CHAMPIONS QUARRY Minor Operational Changes Modification (PA 09_0080 MOD 2)

Environmental Assessment Report Section 75W of the *Environmental Planning and Assessment Act 1979*

Plan of Biodiversity Offset Areas

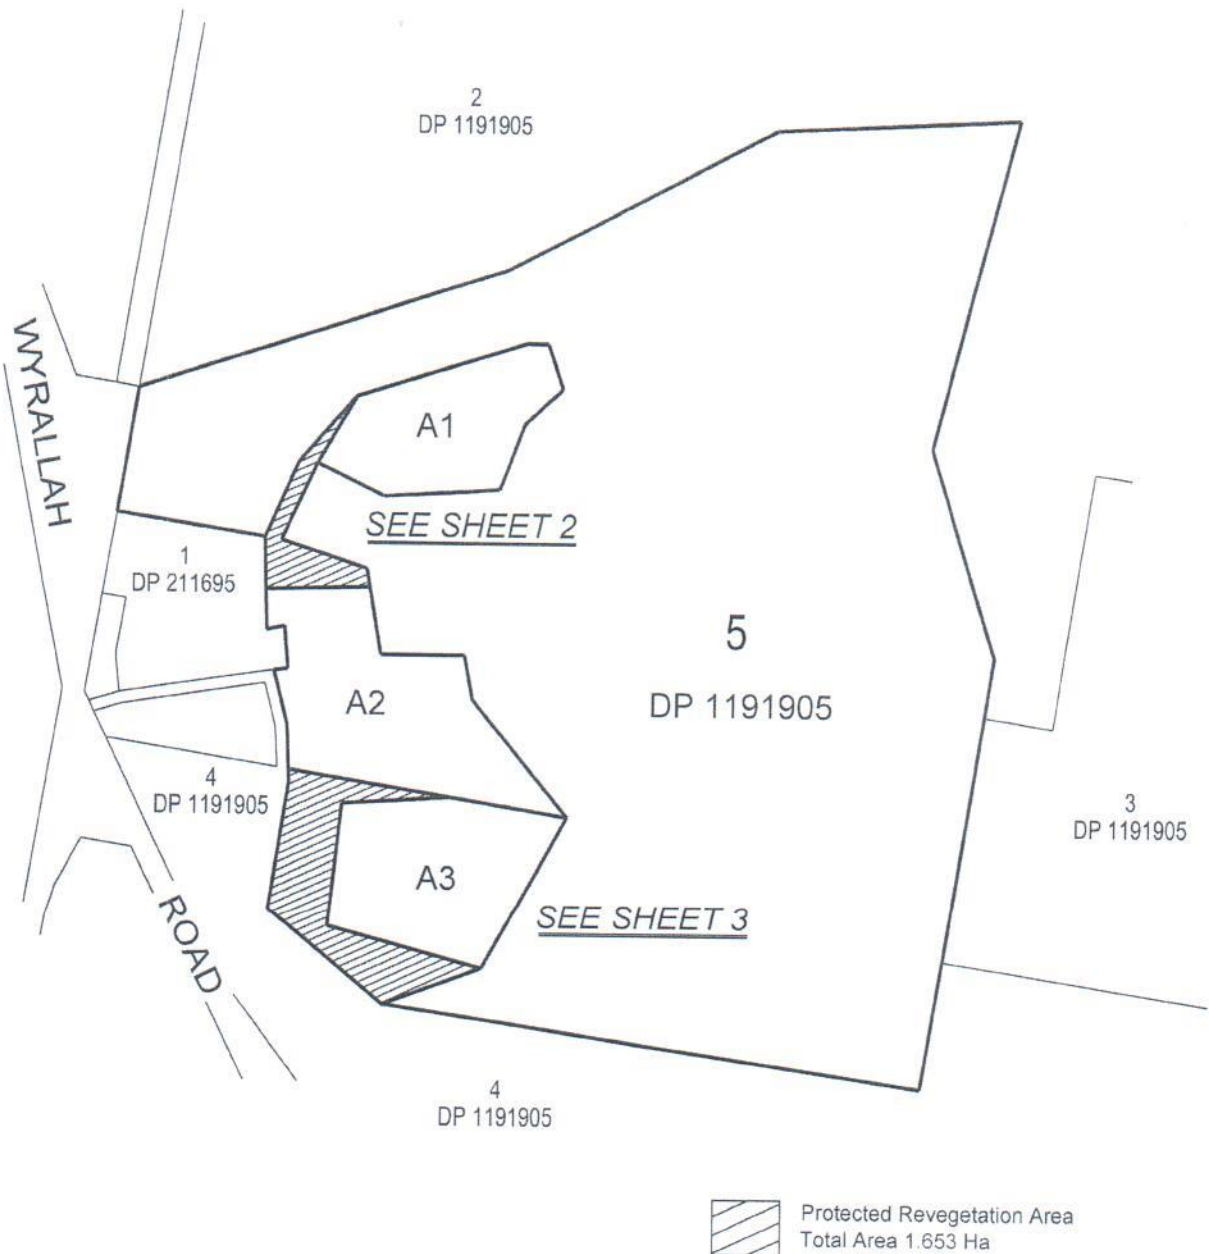
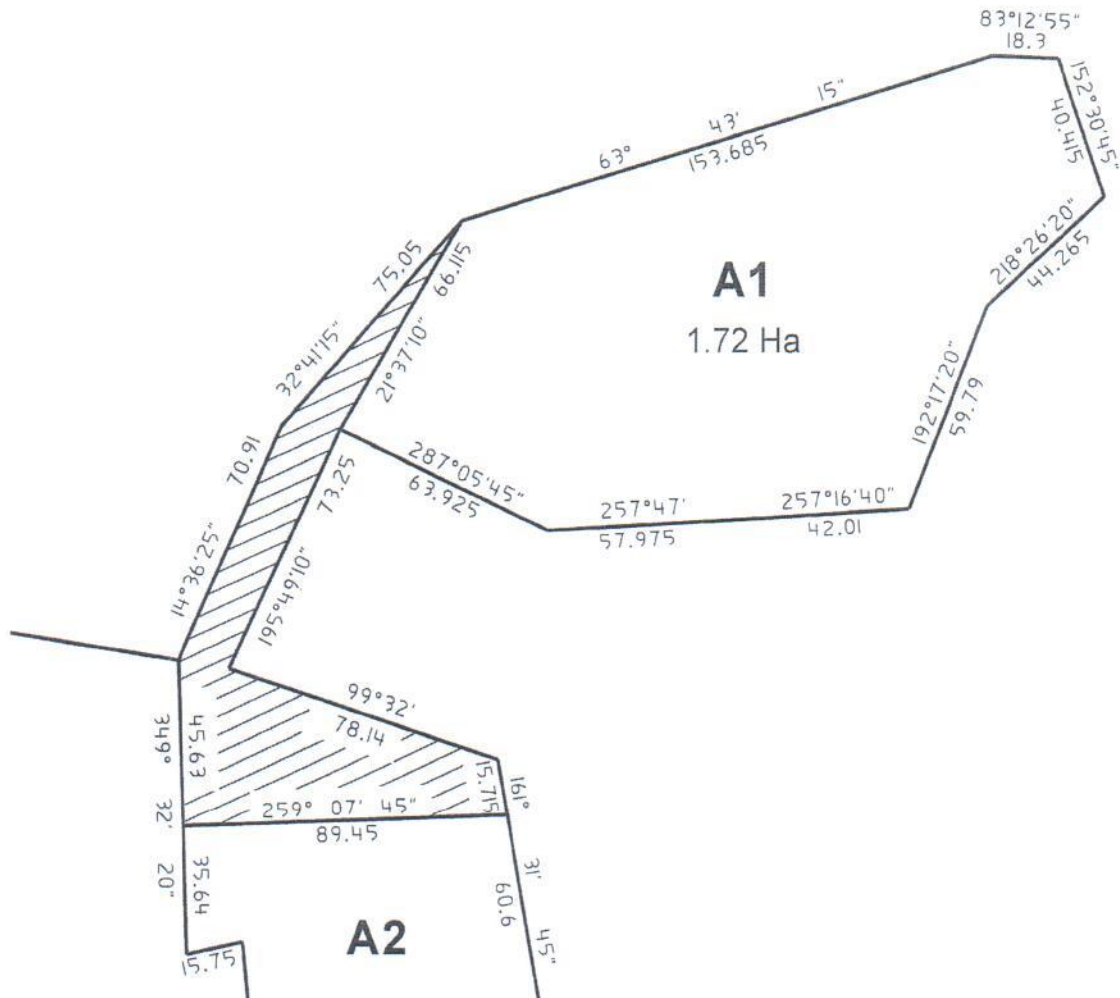
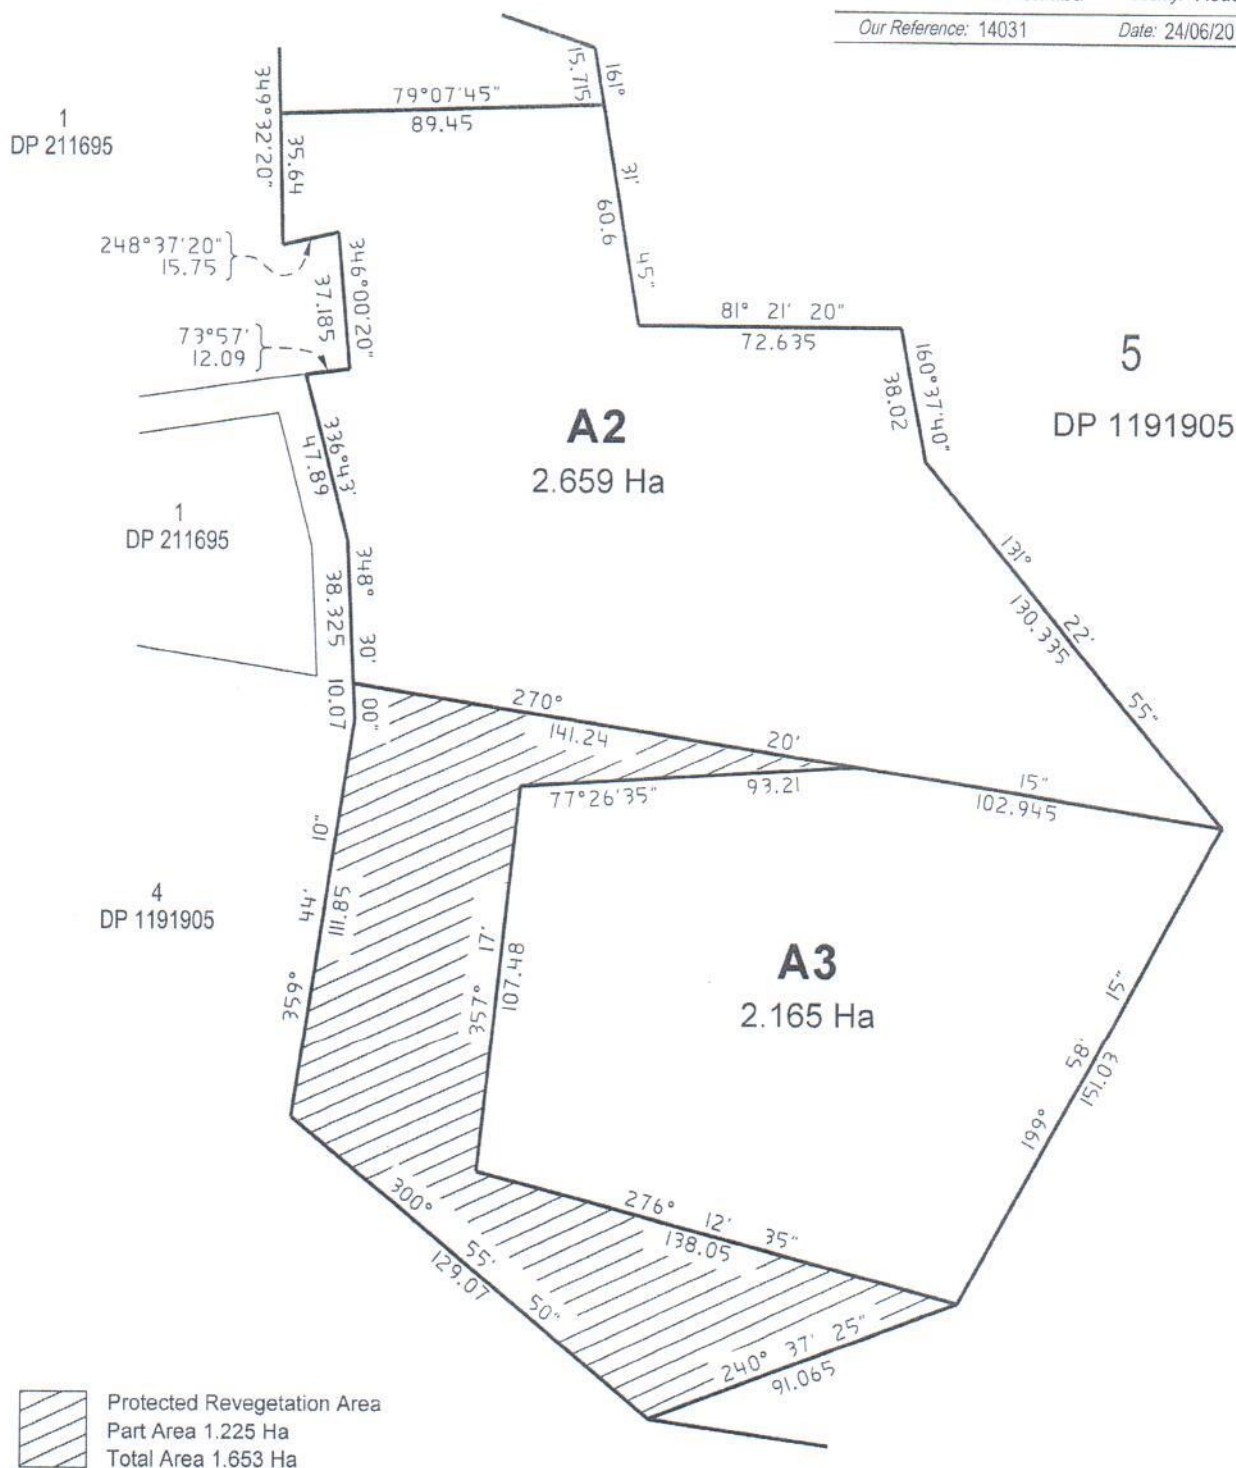
Champions also requested that the figure in Appendix 6 of the project approval be replaced with an updated figure that includes revised boundaries for the Biodiversity Offset Areas that have been ground-truthed and surveyed. Table 7 in condition 40 identifies the area shown in the current figure in Appendix 6 as being conceptual. Champions provided an updated figure with boundaries for the Biodiversity Offset Areas that it claims reflect the vegetation on the ground at the date of survey, which has varied since the areas were originally identified in 2010. Champions has stated that the revised areas satisfy the minimum size requirements contained in Table 7. Champions provided further demonstration of this calculation in its RTS by way of survey drawings. These confirm that the proposed boundaries satisfy the area requirements of Table 7.

However, in reviewing the revised boundaries overlaid on the aerial photo (see **Figure 3**), it can be seen that Champion's revised boundaries would result in less high density/quality vegetation and a greater area of lower density vegetation in the proposed Biodiversity Areas 1, 2 and 3. Conversely, the proposed Protected Revegetation Area would contain high density/quality vegetation and less low density vegetation. This is contrary to the intent of the offset areas and is inconsistent with Champions' claim that the revised boundaries are in part the result of ground-truthing current vegetation.

During discussions with Champions it was confirmed that the revised boundaries for the offset areas were also based on its proposal to provide offset areas that could be efficiently fenced (as stated in the modification application). In so doing, Champions proposed to make maximum use of existing fencing and to maintain a 50 metre (m) buffer between the offset areas and the quarry extraction area. Champions interpreted that providing the 50 m buffer to the offset area boundary would satisfy Schedule 3 condition 37 which requires "*that the edge of the Southern Extraction Area is setback at least 50 metres from the mapped Dry Rainforest/Lowland Rainforest EEC on site.*" The Department's position is that a 50 m buffer does not in itself satisfy condition 37 because the buffer needs to be provided to the physical edge of the mapped Dry Rainforest/Lowland Rainforest EEC.

On 6 May 2016, the Department informed Champions that it was not satisfied with the Biodiversity Offset Area boundaries as proposed in MOD 2 and requested that they be revised. On 8 August 2016, Champions provided a figure showing the revised Biodiversity Offset Areas that addressed the Department's concerns (see **Figure 5**). The Department considers that the revised Biodiversity Offset Areas and Protected Revegetation Areas now more closely reflect the conceptual areas identified in Figure 9 in Appendix 6. More of the high density/quality vegetation is now contained in the Biodiversity Offset Areas, the lower density/quality vegetation is now contained in the Protected Revegetation Areas and the minimum size requirements for each area have been either met or exceeded. In fact the proposed revised BOS results in an increase in area protected by 0.653 ha, when compared with that currently required by condition 40.

The proposed revised Biodiversity Offset Areas will result in a buffer distance between the extraction areas and the offset areas of at least 25 m. As noted above, condition 37 requires a setback of the Southern Extraction from the mapped Dry Rainforest/Lowland Rainforest EEC of 50 m, not a setback from the offset areas. The Department considers that the intent of condition 37 has been met and that the Biodiversity Offset Strategy as shown in **Figure 5** provides appropriate ongoing protection for the native vegetation on site. Further, other quarrying activities (for example haul roads or dams) are permitted within this 'buffer' zone and such activities have taken place (see **Figure 5**). For these reasons, the Department considers that condition 37 is ineffective and recommends that it is deleted from the approval.

Figure 2: Location of Internal Haul Road

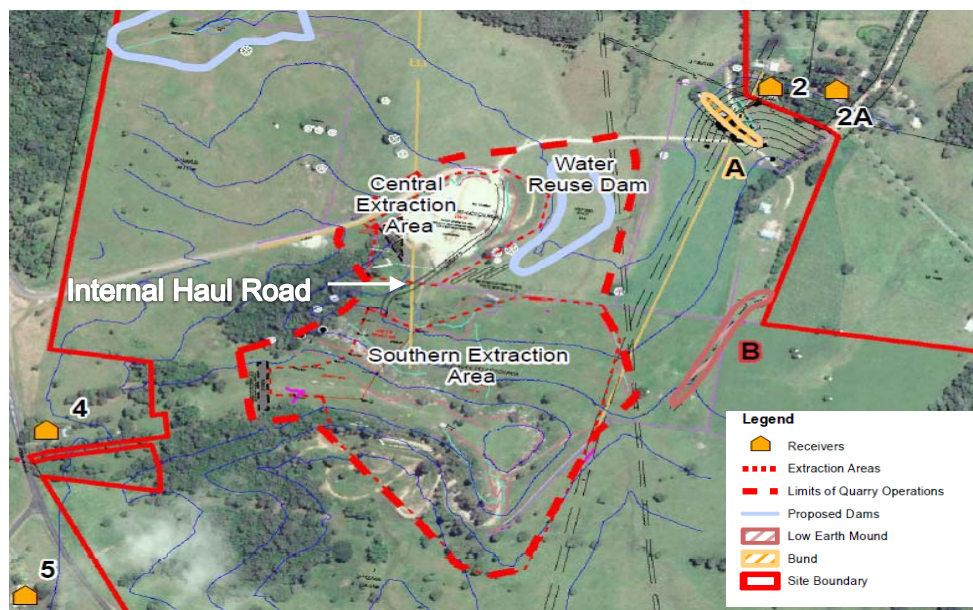
The sealing of the internal haul road between the Central and Southern Extraction Areas was proposed as part of the dust control measures contained in the 2009 project application and EA. Champions has stated that sealing the haul road is impractical as heavy machinery would rip up the seal, resulting in potential contamination of product, and has requested that watering the haul road be allowed as an alternative.

As noted in correspondence dated 13 January 2015 from the Department to Champions Quarry, the Department has previously accepted that sealing the internal haul road would be of little benefit and would likely be damaged by heavy vehicles. The key issue is whether the sealing of the internal haul road is necessary for the quarry to meet air quality criteria and whether watering of the haul road is a satisfactory alternative. As identified in the 2009 EA (see Table C1: Emissions Estimation in the Air Quality Assessment (ERM, November 2009)), the air quality modelling assumed that internal haulage would be on unsealed roads. There were also a number of other factors which led to the model and its predictions being conservative. Nonetheless, the Air Quality Assessment predicted that the quarry could meet all air quality criteria at all private residences. Champions is currently complying with air quality criteria, as detailed in its 2015 and 2016 Annual Reviews.

The Department considers that watering of internal haul roads at a rate of 2 litres per m² per minute is an acceptable method of controlling dust from haul roads. The Department is satisfied that watering the internal haul road between the Central and Southern Extraction Areas as an alternative to sealing the road is a satisfactory and practical method of controlling dust.
